City of Portland, Maine - Building or Use Permit Application

Permit No: 10-0451	Issue Date:	CBL: 055 B041001
------------------------------	--------------------	----------------------------

Location of Construction: 214 BRACKETT ST apt1	Owner Name: REED TRACIE J & JOSHUA REE	Owner Address: 121 BRITTANY MNR # D	Phone:
Business Name:	Contractor Name: Josh Reed	Contractor Address: 214 Brackett St Apt 1 Portland	Phone 2073298857
Lessee/Buyer's Name	Phone:	Permit Type: Additions - Multi Family	Zone:

Past Use: 3 unit residential	Proposed Use: 3 unit residential - additon of new exterior doorway, w/ deck platform, stairs to ground level apt 1	Permit Fee: \$30.00	Cost of Work: \$1,000.00	CEO District: 2
Proposed Project Description: addition of new exterior doorway, w/ deck platform, stairs to ground level apt 1		FIRE DEPT: <input type="checkbox"/> Approved <input type="checkbox"/> Denied	INSPECTION: Use Group: Type:	
		Signature:	Signature:	
PEDESTRIAN ACTIVITIES DISTRICT (P.A.D.)				
Action: <input type="checkbox"/> Approved <input type="checkbox"/> Approved w/Conditions <input type="checkbox"/> Denied				
		Signature:	Date:

214 Brackett St. (site Plan)
Revised

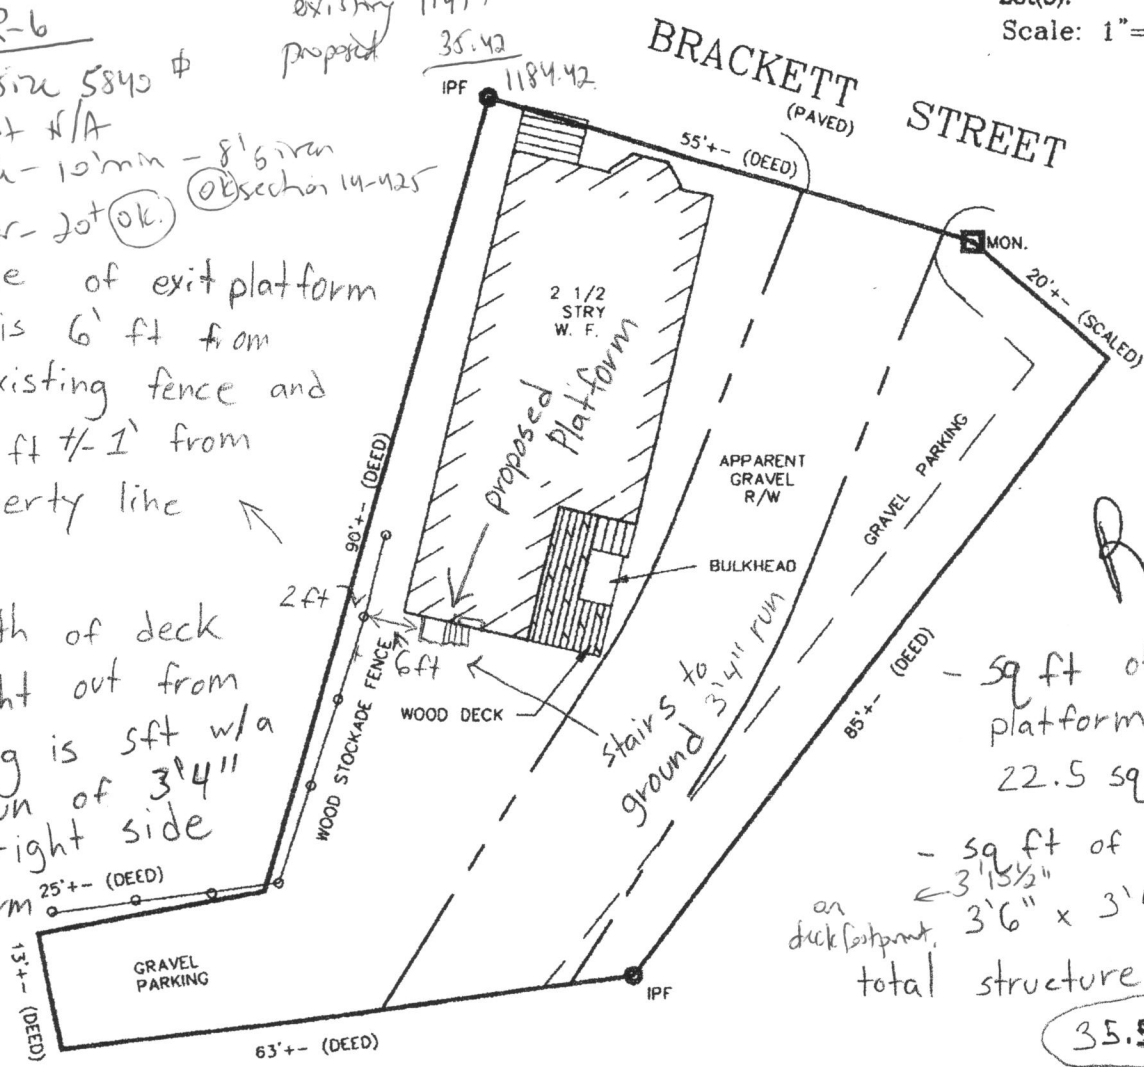
5/6/2010-amachado: Left vcm for Josh Reed. Plot plan is incomplete. Need lot lines drawn, full lot shown & dimensions to side & rear property lines. Need total dimensions including the stairs. Question on the size of the deck - permit says 180 sf but dimensions are 4'6" x 3'4". Need siteplan exemption.

5/7/2010-amachado: Met with Josh at counter. Gave him a plot plan from an old permit. The entry deck & stairs might not meet the 10' side setback. Told him about section 14-425. He might have to put the steps to the side so the footprint does not come more than 6' off the building. Gave him a siteplan exemption applicaton.

Dept: Zoning **Status:** Approved with Conditions **Reviewer:** Ann Machado **Approval Date:** 05/11/2010
Note: Using section 14-425. The platform comes out 5' and the total square footage is 35.5 sf. **Ok to Issue:**

(Master landscape plan)
Revised

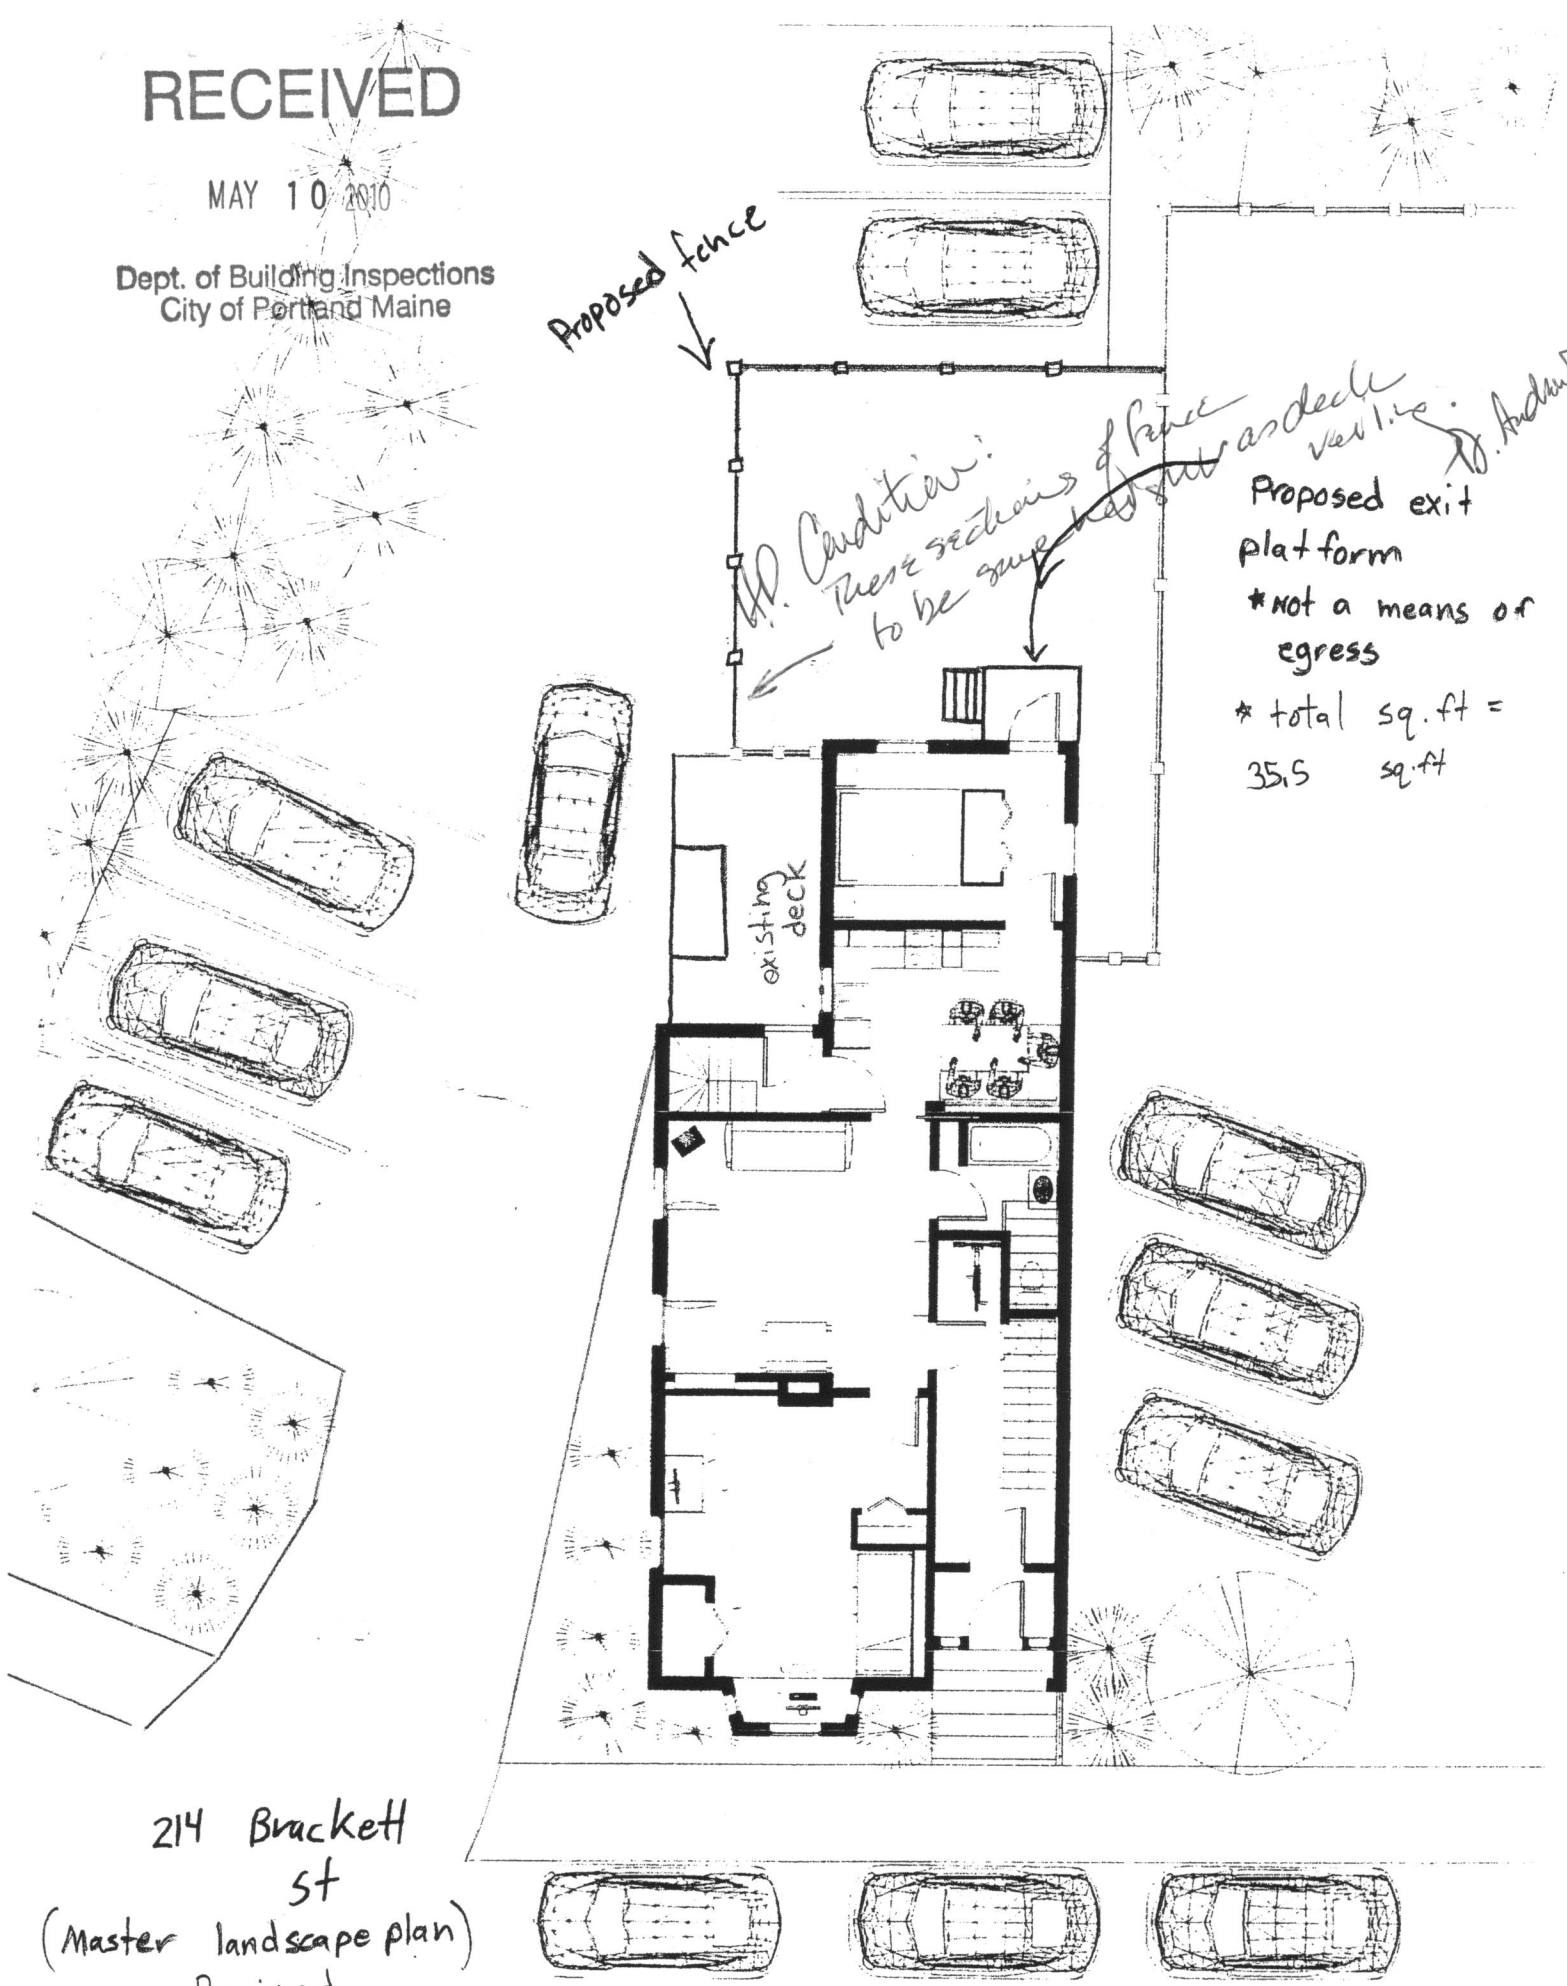
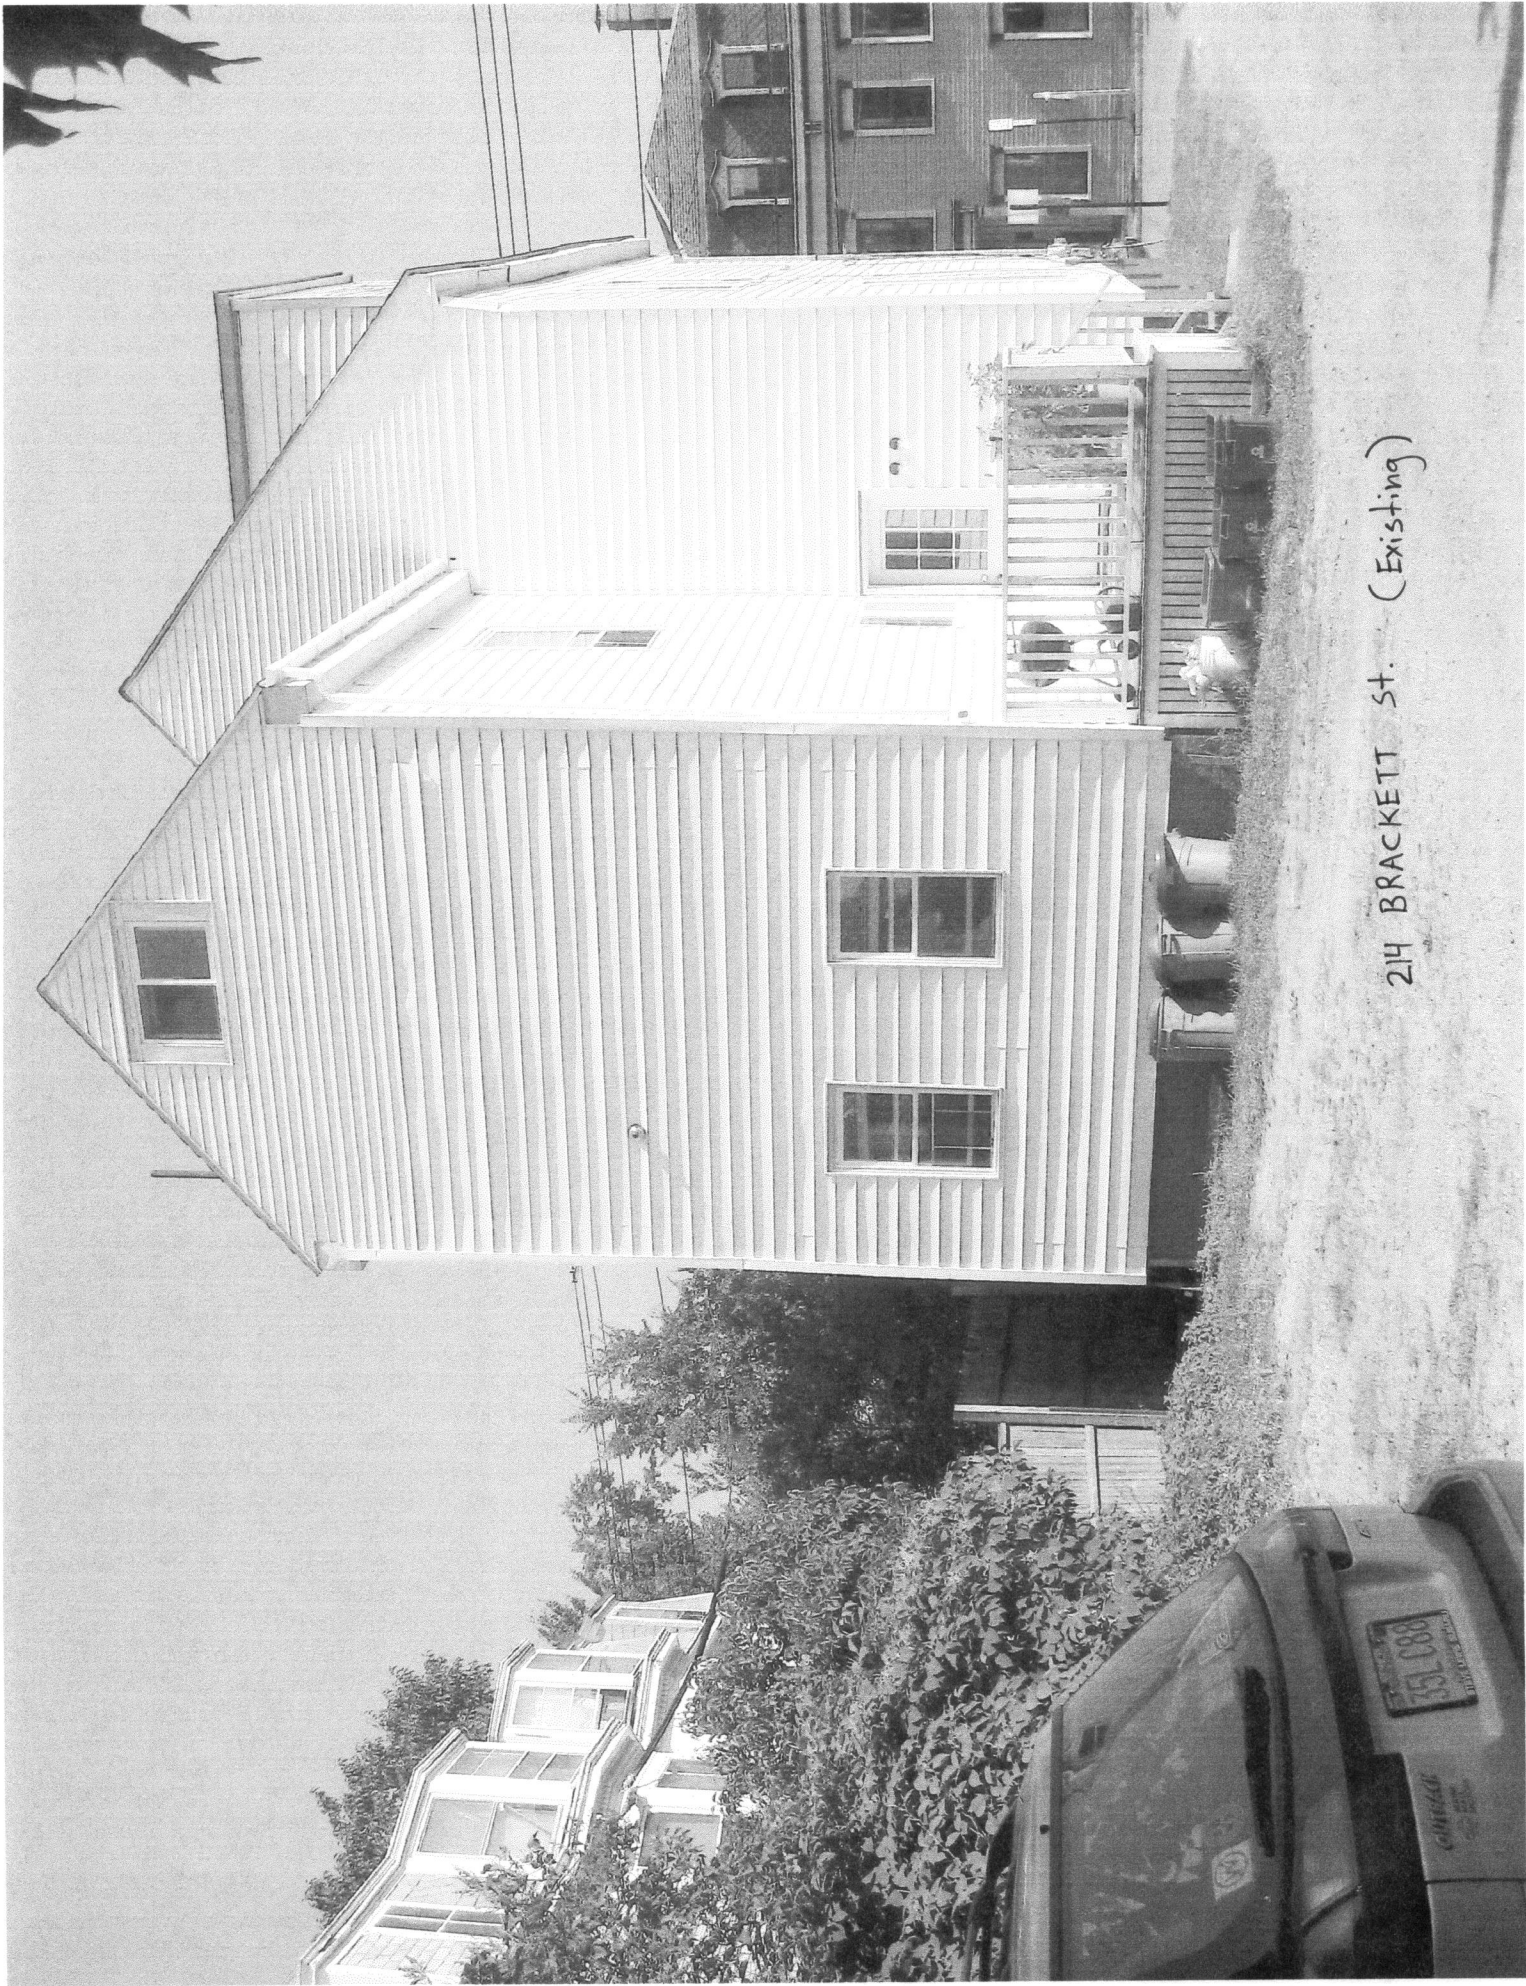
- 1) * Exterior door and deck not visible from street; no review required.
- * Fence installation to be as shown on marked up site plan.

214 Brackett St.
Revised

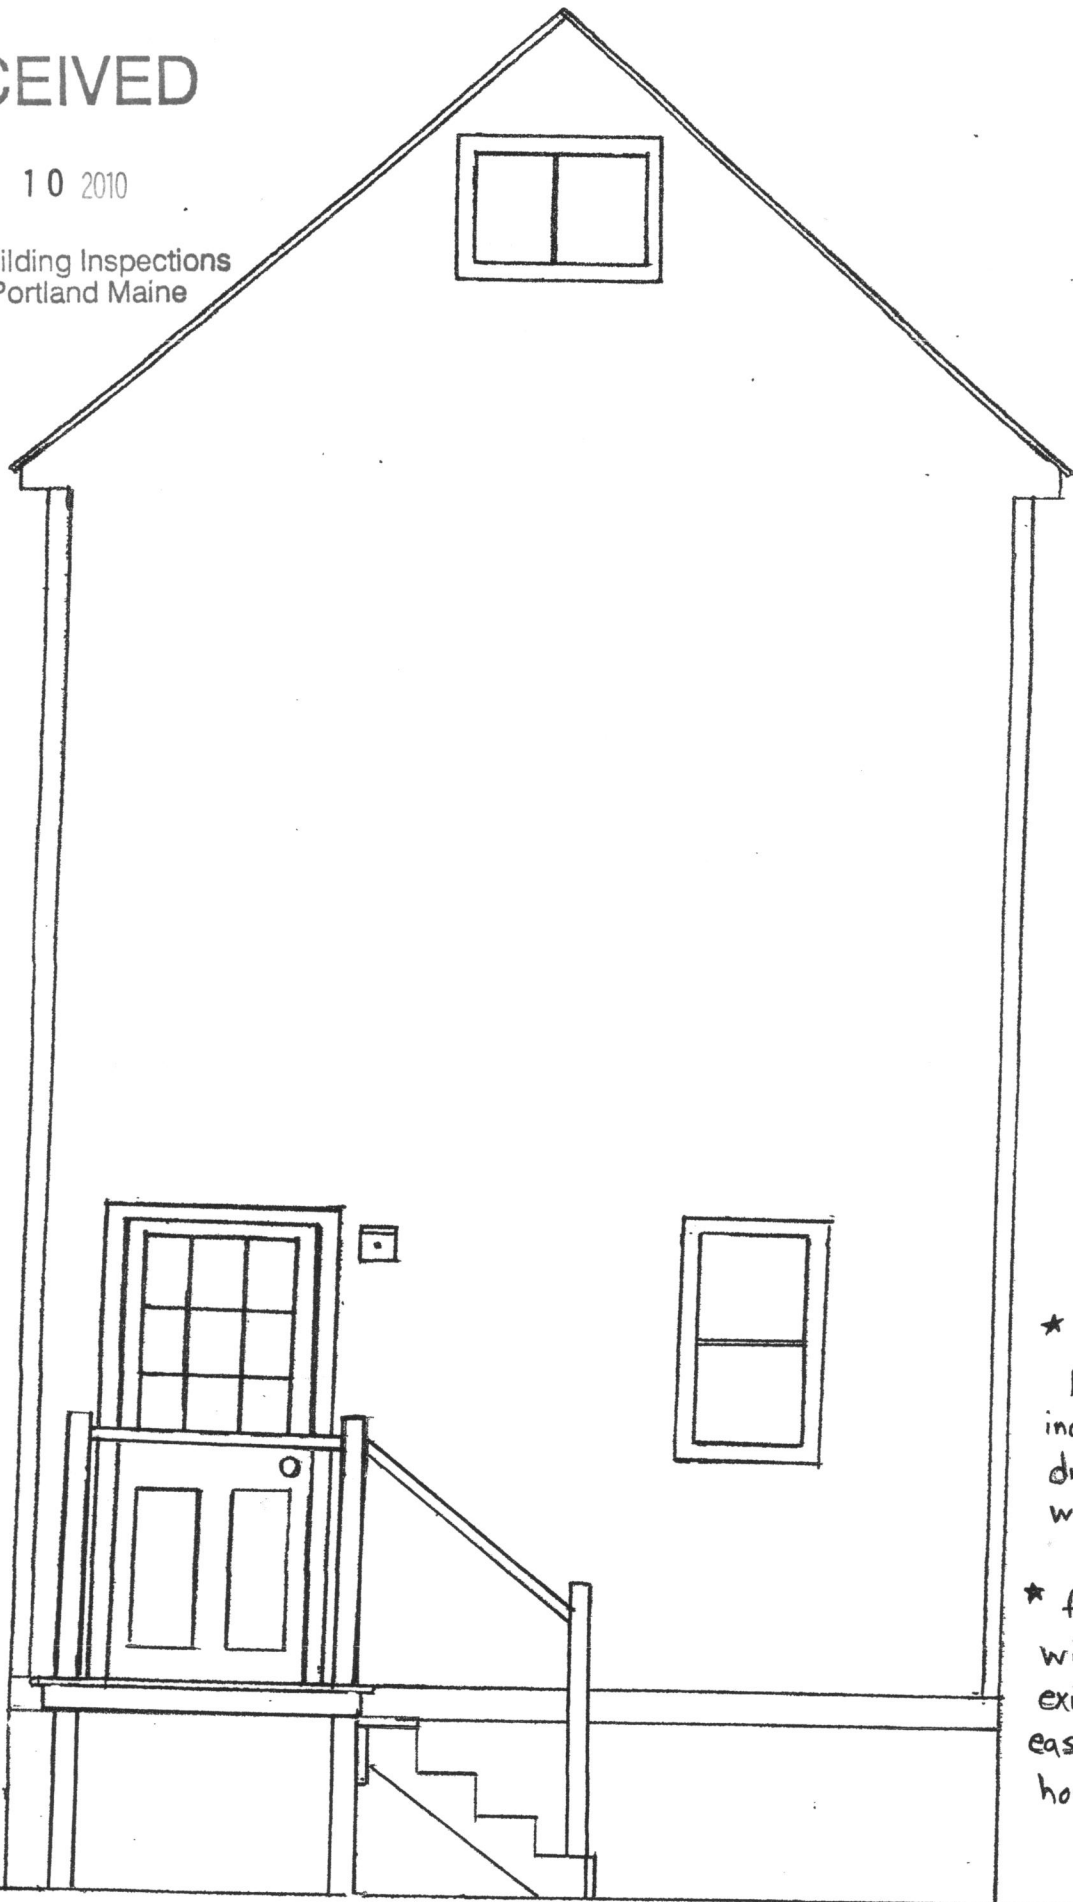
5/24/2010-jmb: Spoke to Josh R. for details on graspable handrail, frost depth, solid risers. This entry serves only one unit and it is historic, allowed to meet IRC 2003 code requirements
